96 BILL LEATHEM DRIVE CHELLO Commercial Development

Design Brief

21 March 2024

**Subject: Phase 3 Pre-Consultation: Review Feedback
Proposed Zoning By-law Amendment & Site Plan Control – 96 Bill
Leathem Drive**

- LEGEND**
- 100 YR HIGH WATER LEVEL
 - 5 YR HIGH WATER LEVEL
 - PROPOSED HIGH RIDGE LINE
 - RD#1 DENOTES PROPOSED ROOF DRAIN NUMBER AND LOCATION
 - SC PROPOSED ROOF SCUPPER LOCATION
 - PROPOSED GENERAL DIRECTION OF LOT GRADING AND SURFACE FLOW

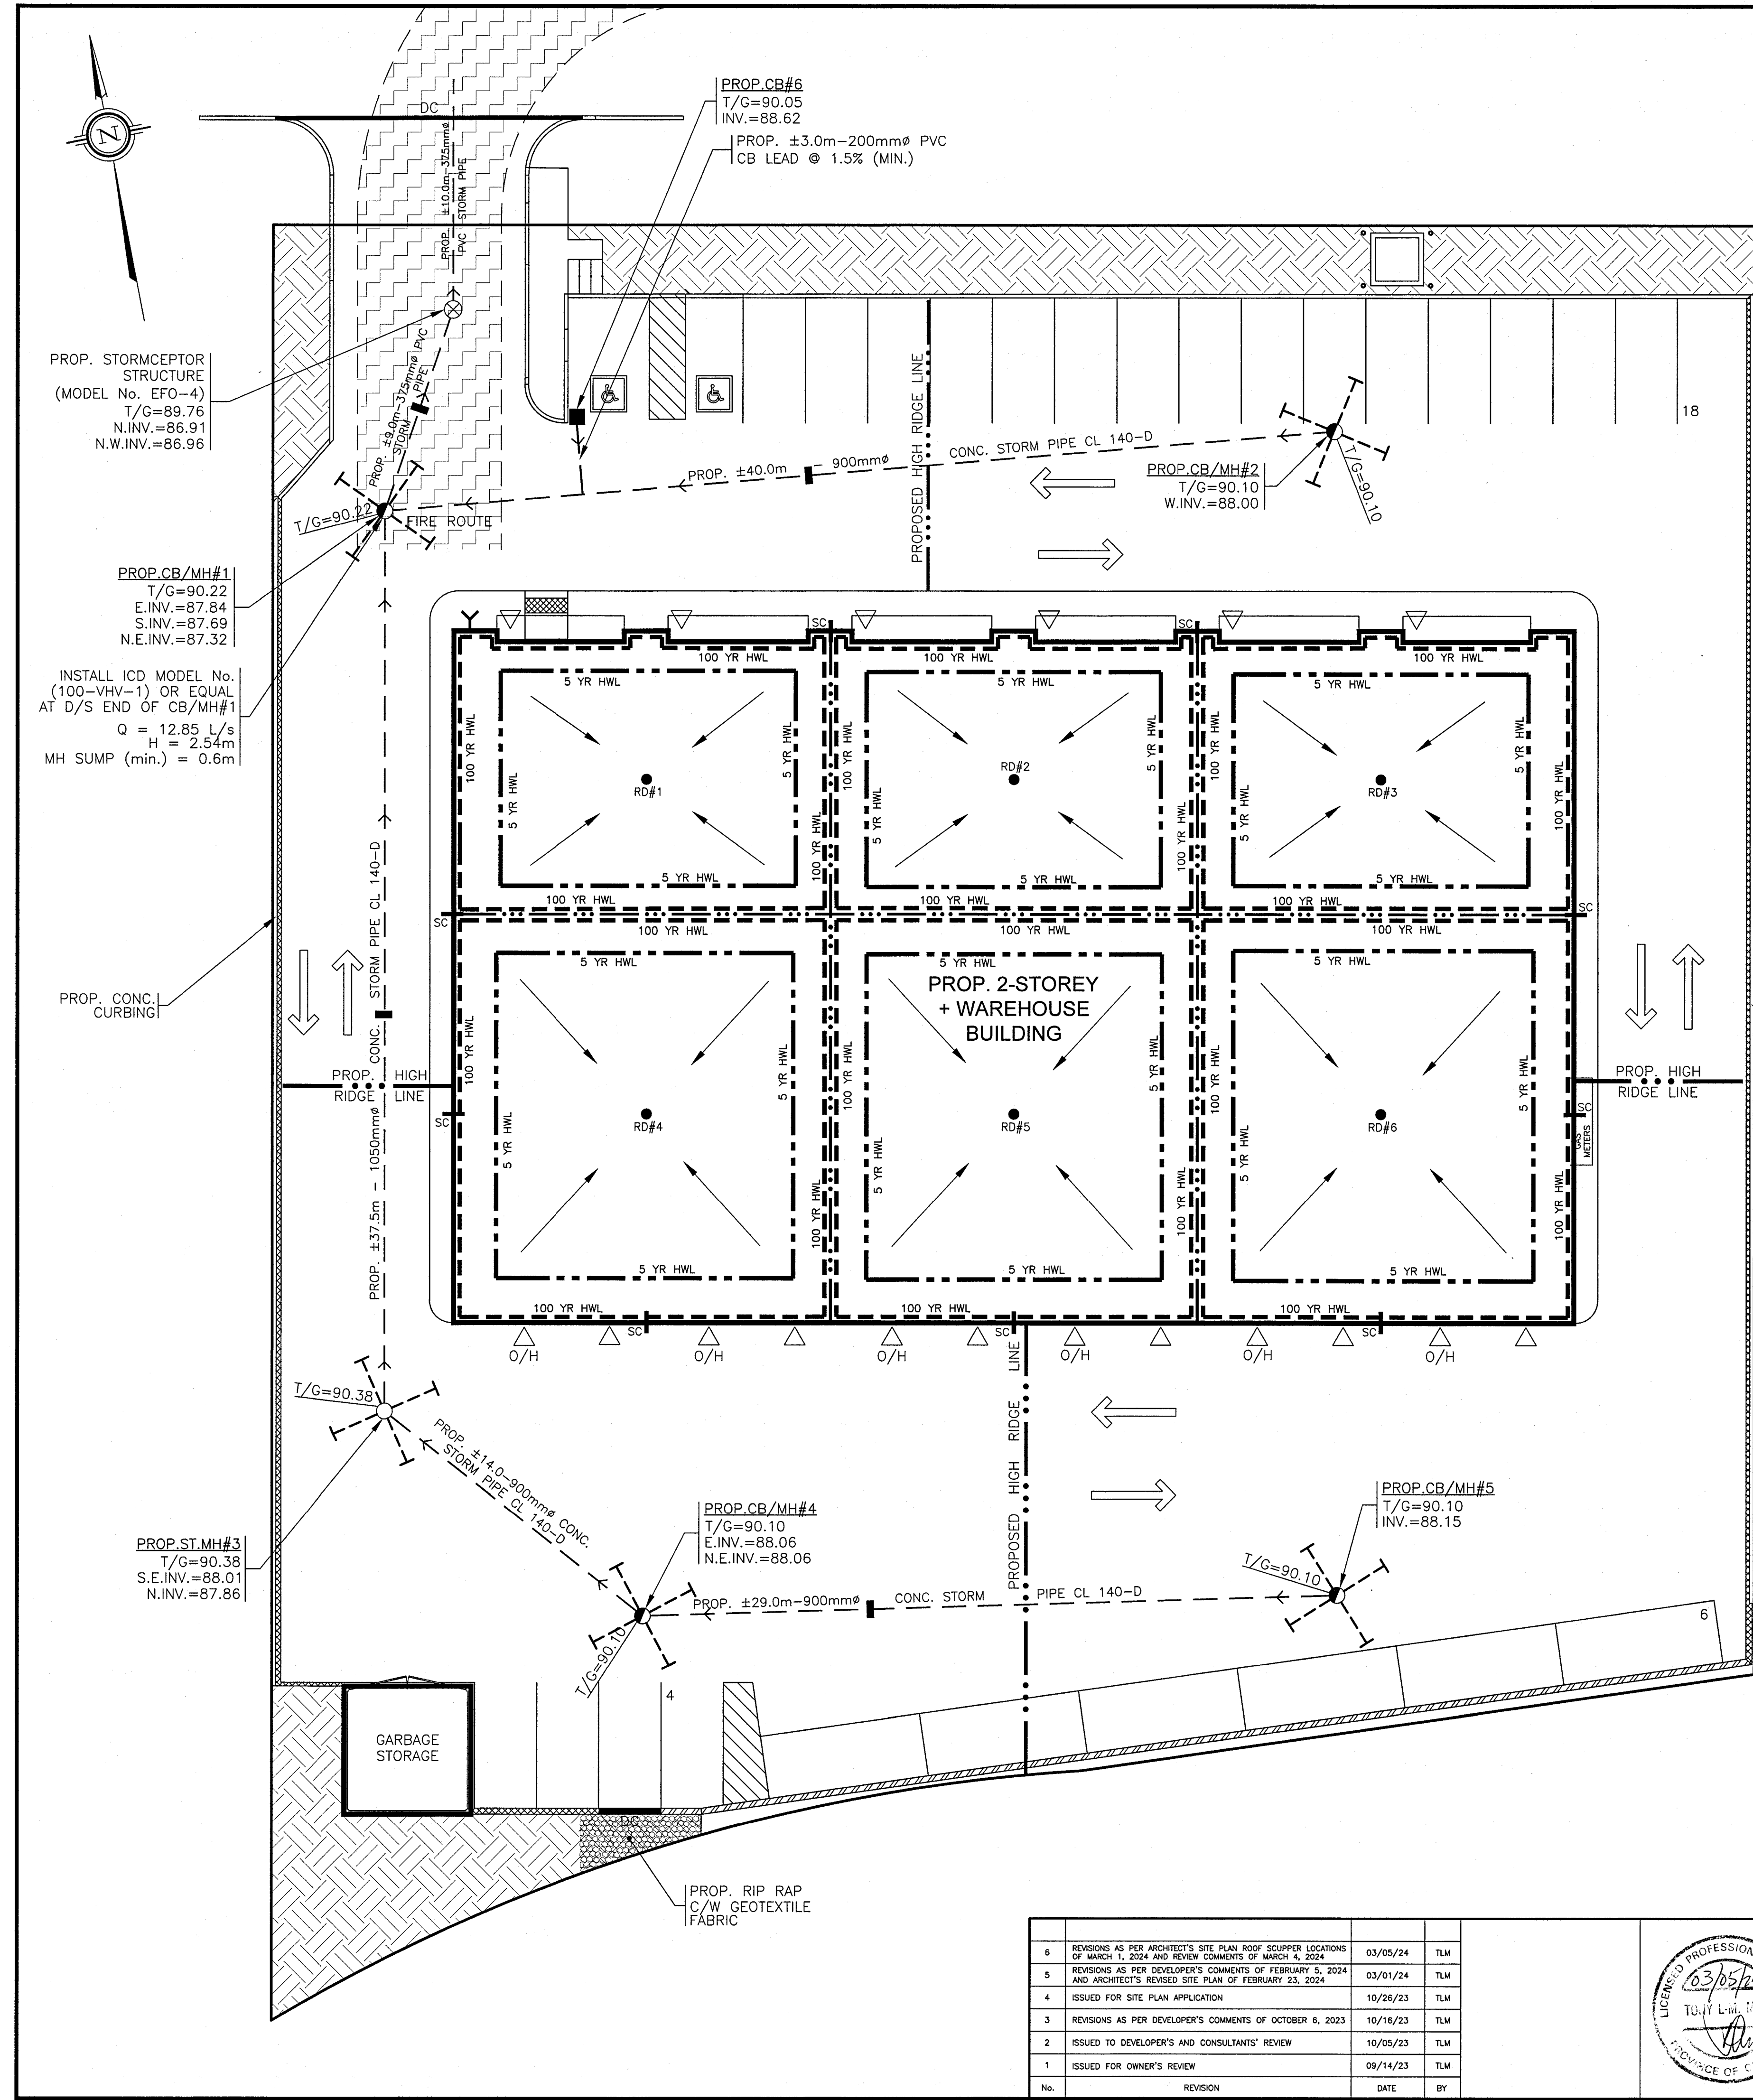
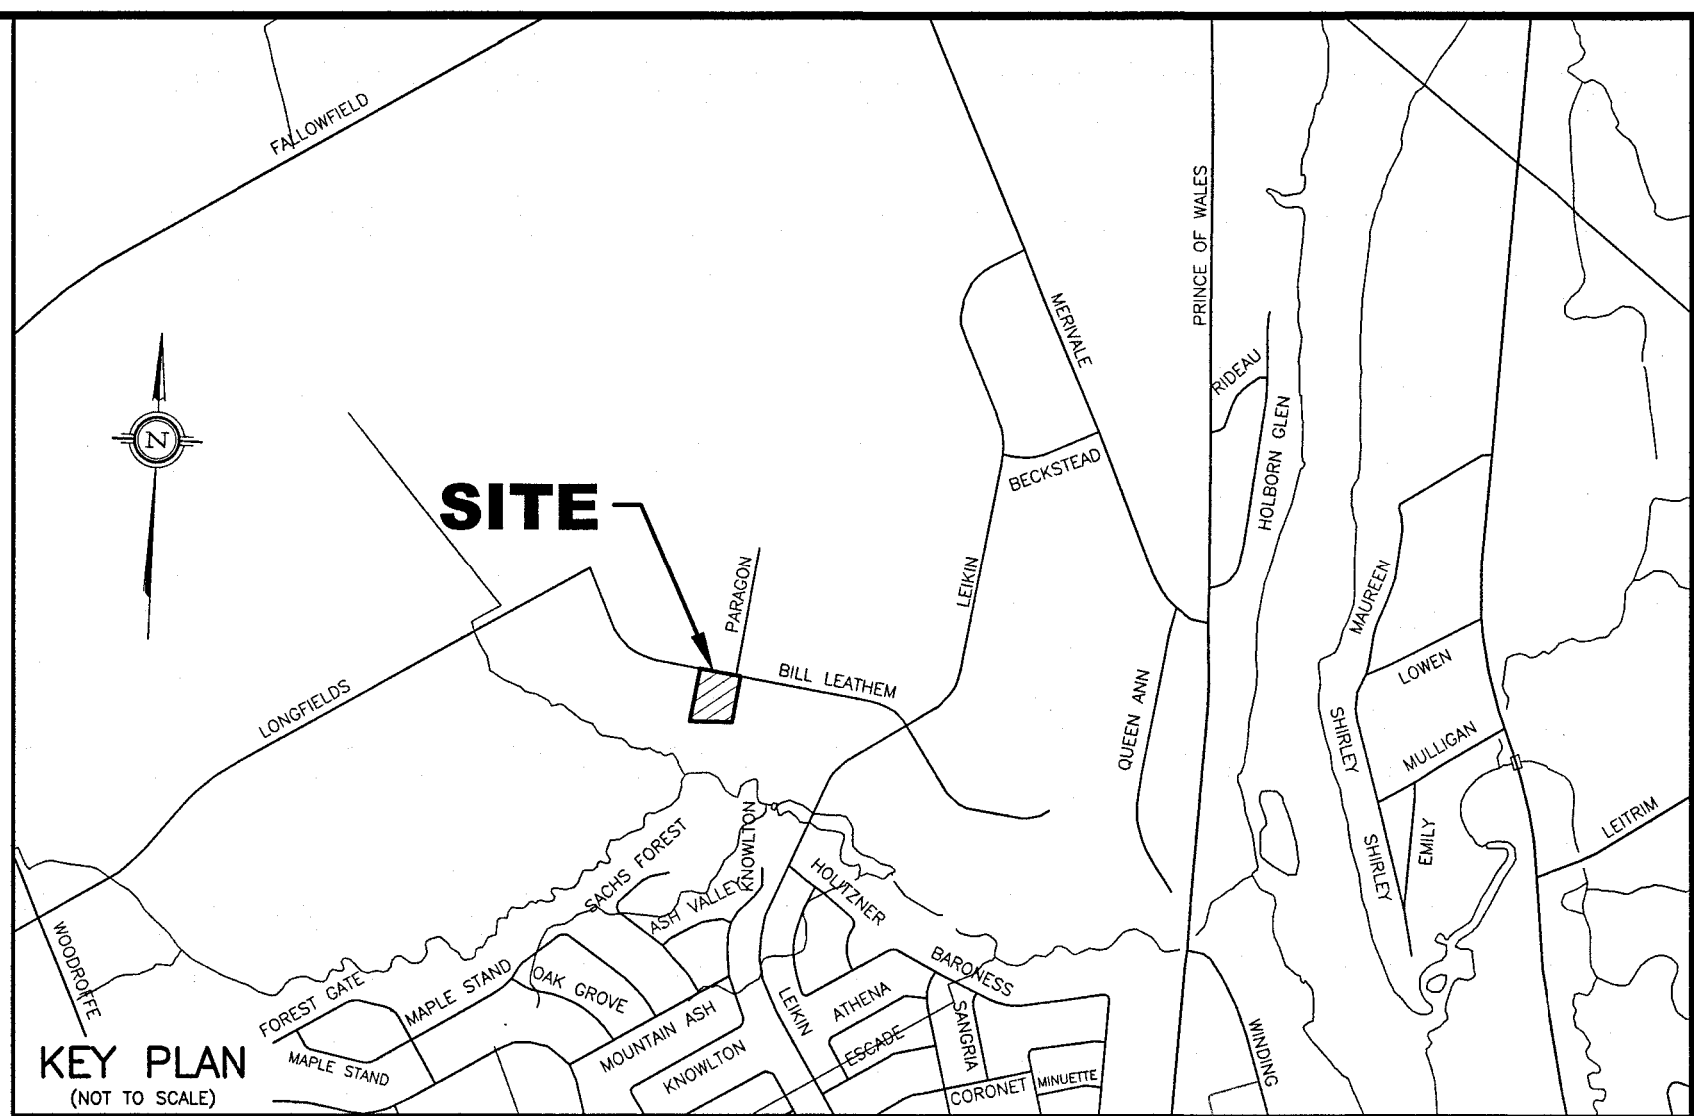
- A1. Only one (1) storm sewer connection to the Bill Leathem right-of-way (ROW) is permitted. Consider grouping the building services into a common sewer before outletting to the ROW. The on-site storm sewer should use the existing 750 mm dia. storm sewer in the Bill Leathem ROW as the outlet.

- A2. Delineate the road cut area(s) on the plan and provide an area (m2) for each road cut. Ensure the road cut extends for an entire lane width per City of Ottawa road cut specifications.

- A3. A sanitary monitoring maintenance hole is required. A sampling port per S18.1 will not be permitted.
- A4. The existing curb-inlet catch basin that is proposed to be relocated, consider changing the frame and cover to a standard catch basin inlet and relocating the inlet to the opposite side of the curb so it is situated within the Bill Leathem roadway. Otherwise, show the proposed relocation on the plan. Refer to City Standards Drawings.

- A5. The Geotechnical Investigation Report for this application is recommending the use of clay seals in all service trenches. Show the locations of the clay seals on the servicing plan and update the notes to include clay seal details.

- A6. The portion of the private approach within the Bill Leathem ROW should be graded at a maximum 2% per the Private Approach By-Law.
- A7. Pipe crossing(s) should be identified on the plan and barrel-to-barrel separation distances between crossing pipes should be provided in table format.

B1. The note for the proposed depressed curb & sidewalk at the private approach should refer to City Standards Drawings. All works within the ROW shall be constructed to City Standards and shall be accompanied with a measurement (m, m2, etc.)

B2. Identify the fire route and snow storage location(s) on the plan.
